Office of Environment & Heritage

RE: Coleambally Solar Farm, Murrumbidgee LGA – Environmental Impact Statement (SSD 8208)

ATTACHMENT A – Detailed comments for the Coleambally Solar Farm Environmental Impact Statement (SSD 8208)

Figure 3-7 PCTs (including condition) within the proposal area.

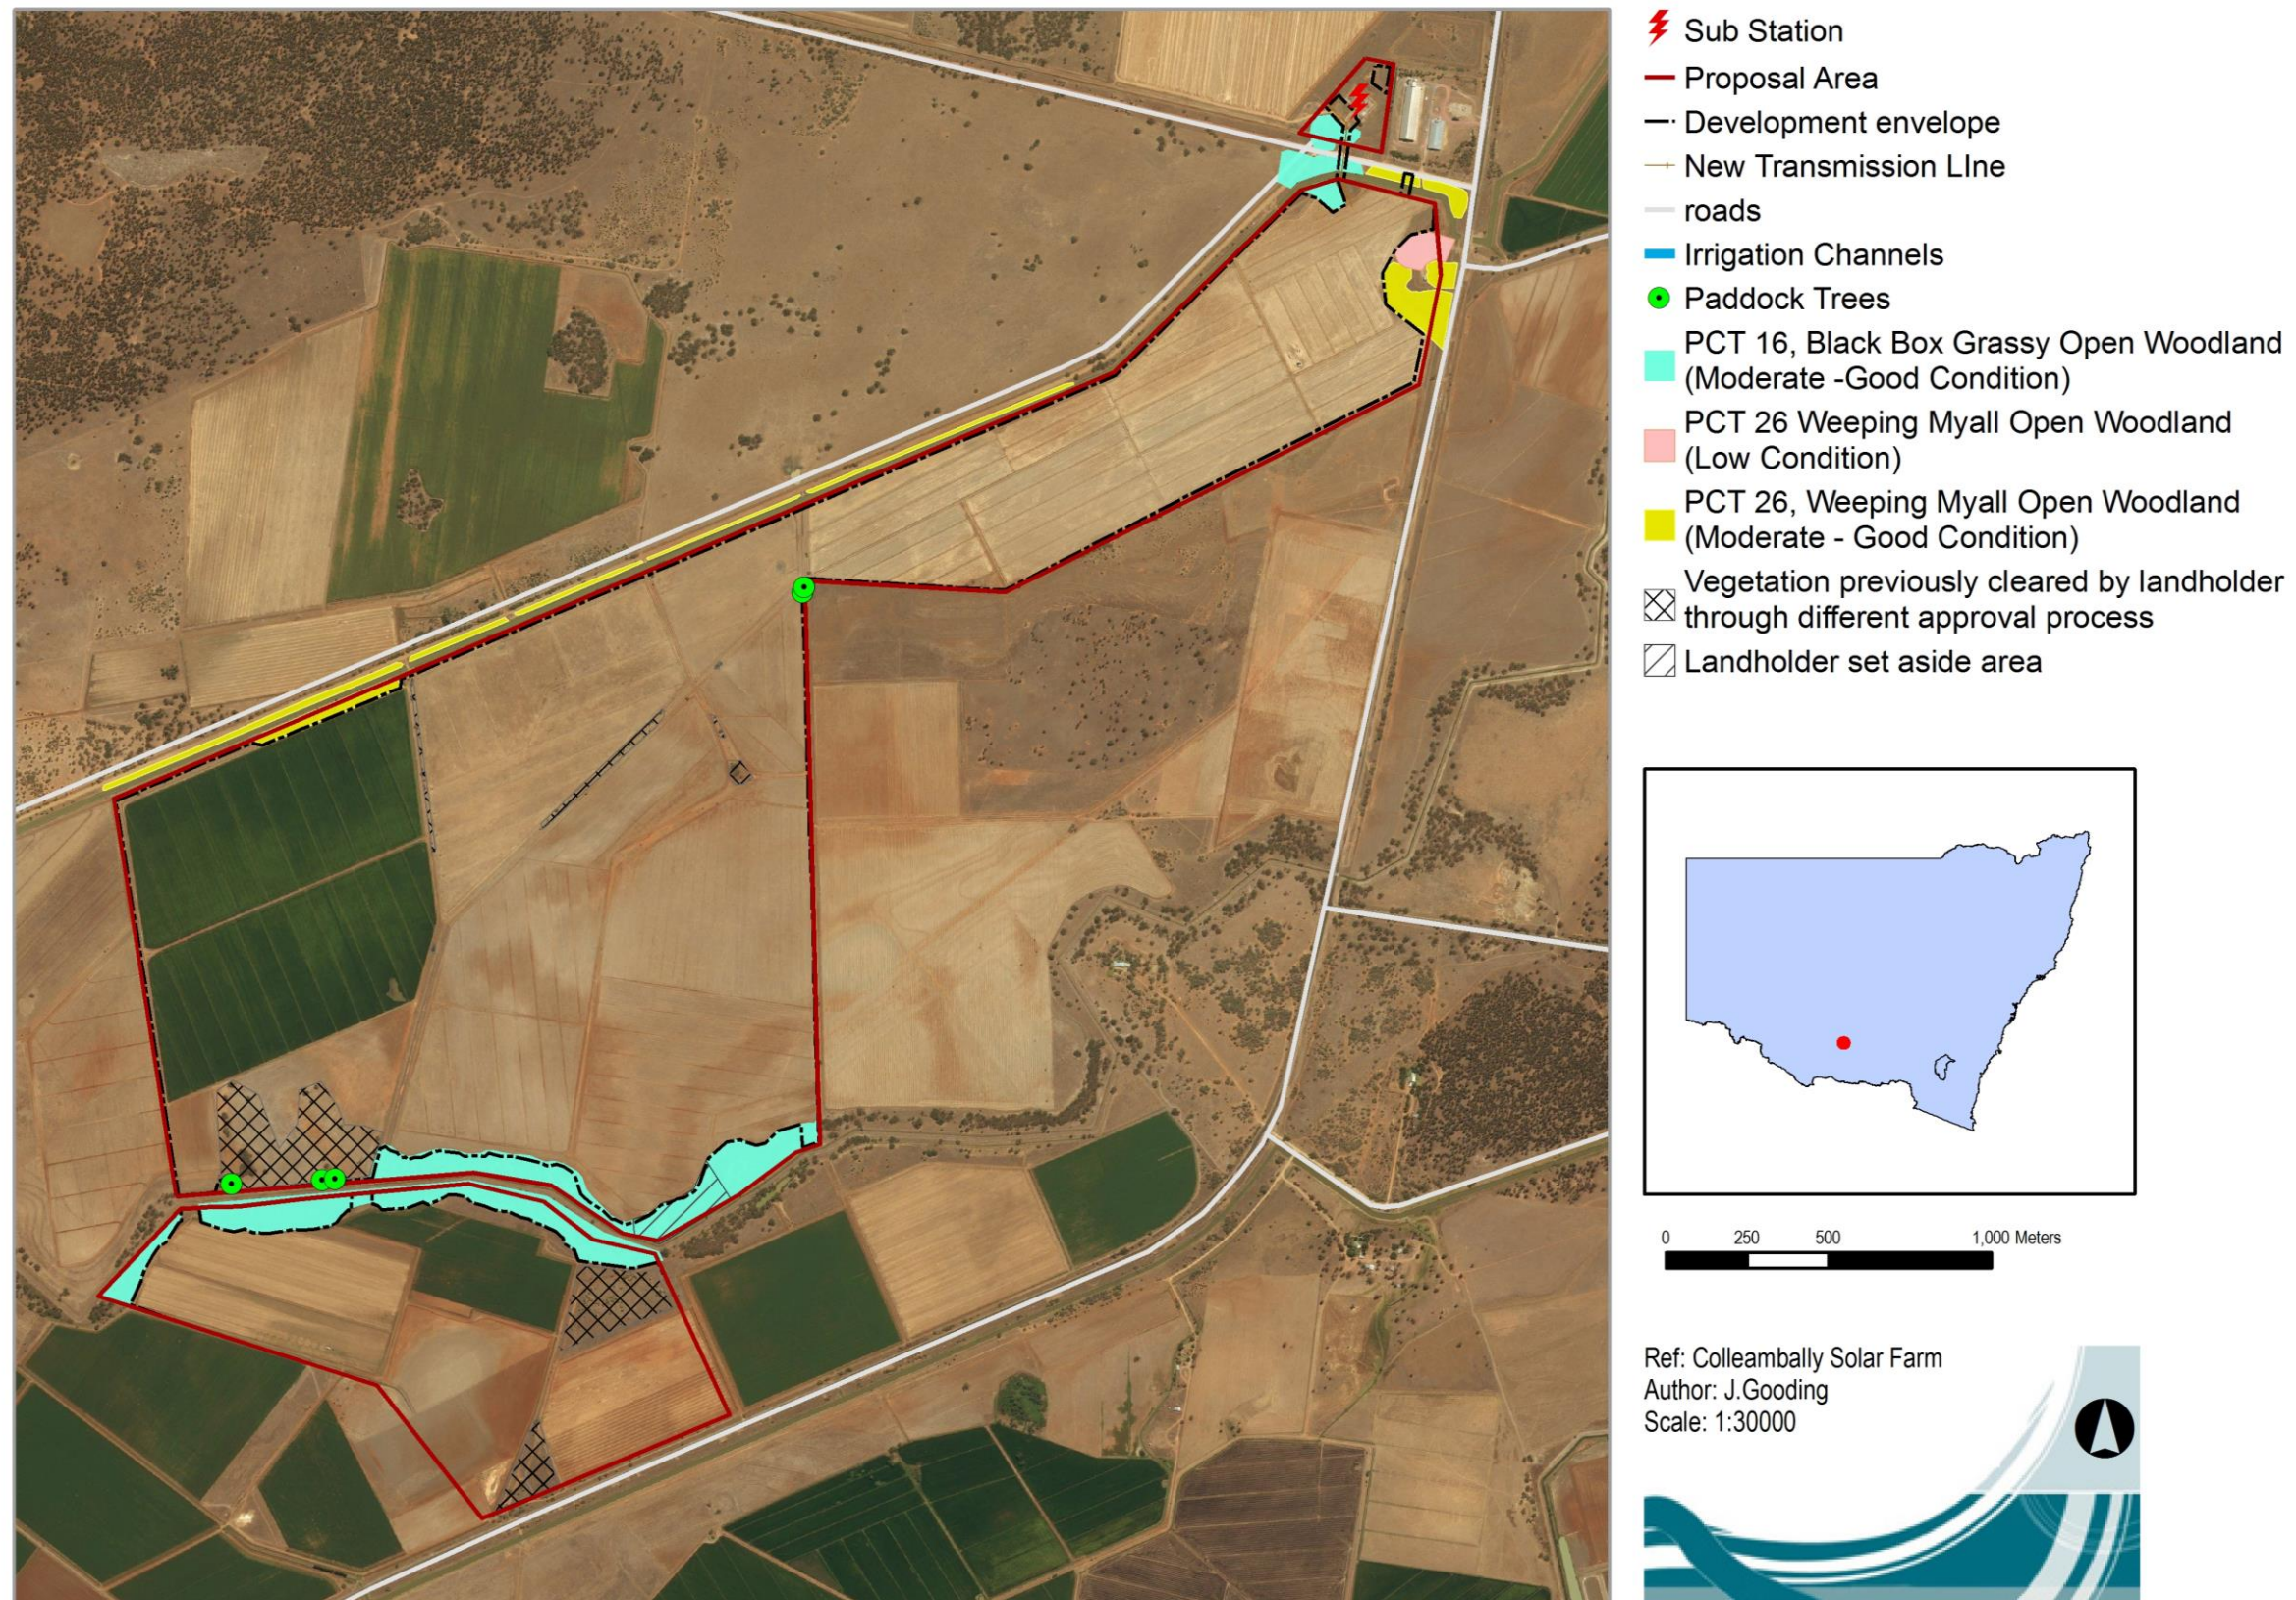
Figure 3-7 (page 17) shows a number of areas that are labelled as 'vegetation previously cleared by landholder through different approval process' and a 'landholder set aside area'. Details of this previously approved native vegetation clearance have not been provided. It is in the interest of the proponent to ensure that this is clarified. Although vegetation clearance may be permitted under the *Native Vegetation Act 2003* it appears that in this case at least some of the areas cleared were not covered by approvals obtained from Riverina Local Land Services. This matter has been referred to OEH Compliance and Regulation for investigation.

The EIS needs to demonstrate that any offsets or set aside areas required under the *Native Vegetation Act 2003* will not be impacted by the proposed development.

- The proponent provide details of the vegetation clearance approvals obtained for the proposal site.

Figure 4-1 Hollow bearing trees within the Proposal Area

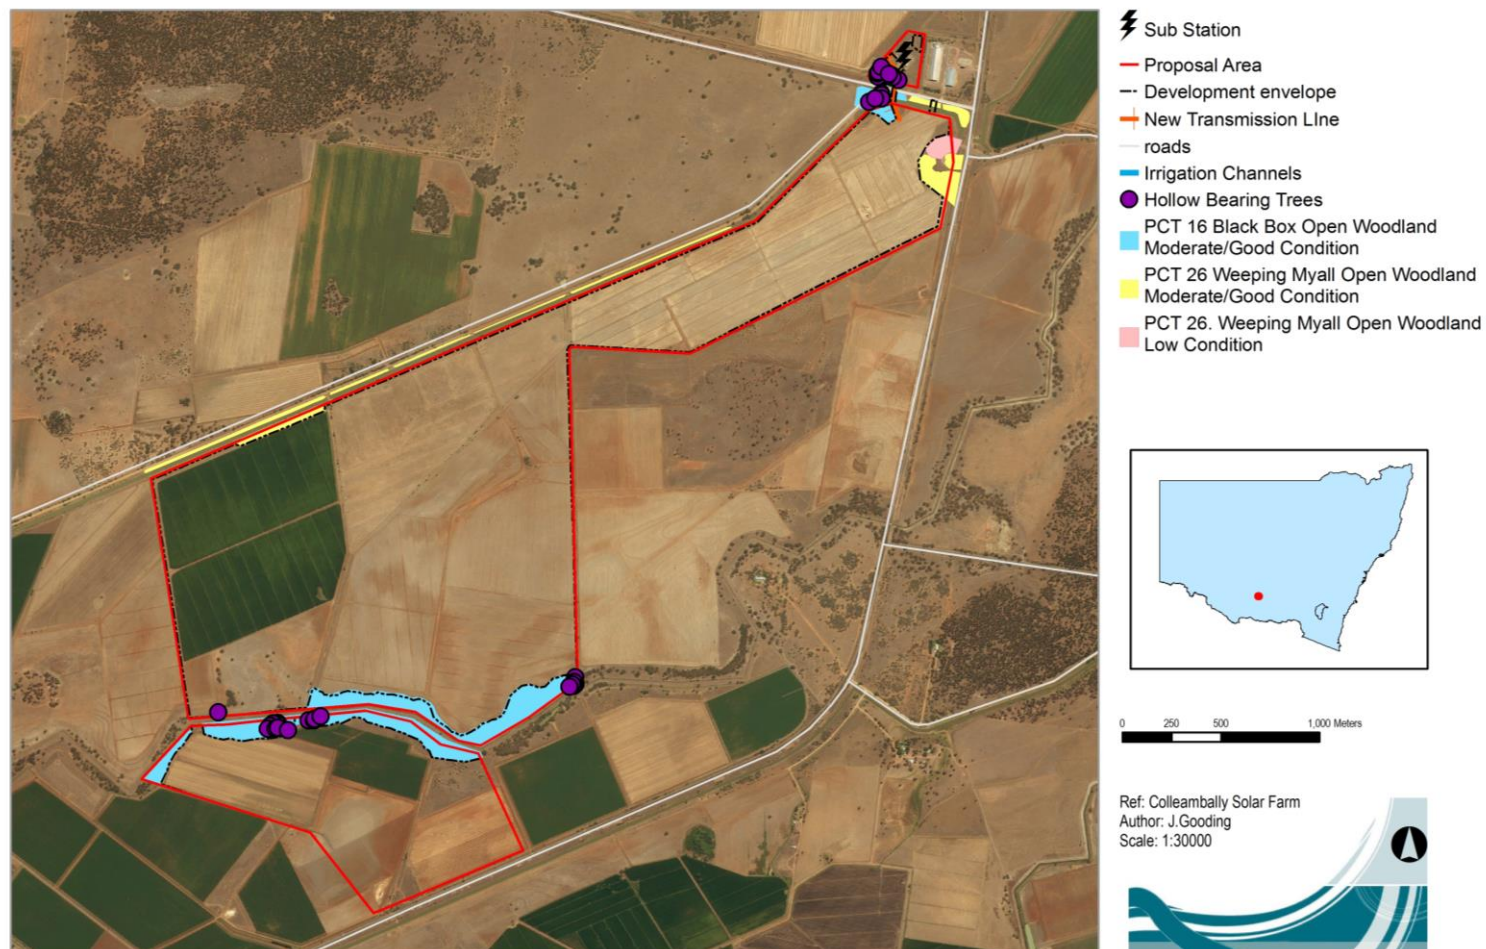
The BAR section 4.2.4 (page 30) states that five hollow bearing trees will be impacted by the proposal (in Zone 3). This is consistent with EIS section 6.2.2 (page 67). However BAR Table 4-3 and text on page 31 refers to six hollow bearing trees to be removed in Zone 3 (possible Squirrel Glider habitat). BAR section 7.3.3 (page 51) refers to five hollow bearing trees to be removed. It is not clear from BAR Figure 4-1 or Appendix B Hollow bearing tree data whether five or six hollow bearing trees are to be removed and this needs to be clarified.

- The correct landscape value score to be stated in the BAR.
 - The correct PCTs be submitted to the Credit Calculator and referred to in the BAR.
 - The number of hollow bearing trees to be removed to be confirmed and reported consistently in the revised BAR.
